Helicopter Pad Relocation Noise Studies

Jean Fraser <jf@portlandmaine.gov>

Fri, Feb 16, 2018 at 4:40 PM

*Appendix 6: 2017 Sound Study Measurement Locations*

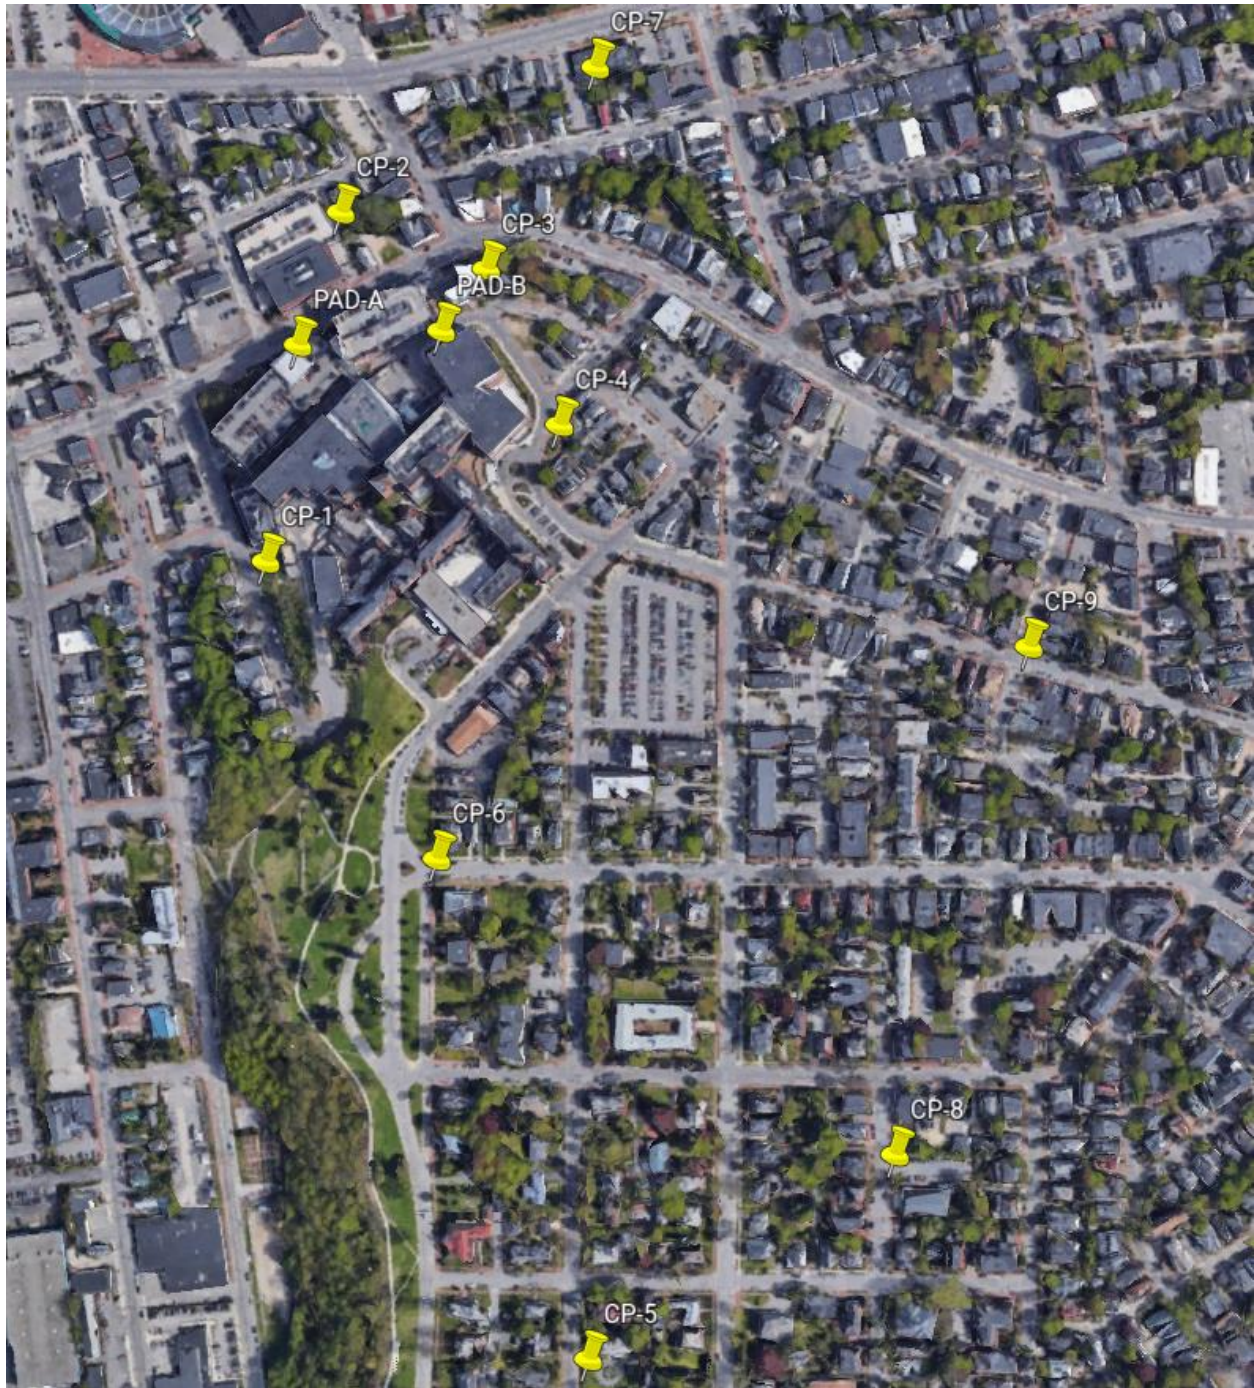
While I appreciate that the Russell Acoustics, LLC May 2017 sound study (attached) used the same locations as the original study, it does not include this data for all of these locations.

Could you please send the recent data that shows the ambient, helicopter sound (based on the current helicopter pad location), and predicted helicopter sound (new location, main pad) for each of the nine CP locations so that we can see the data that underpins the submitted summary. Could you please send that data in a table linked to the plan of the locations.
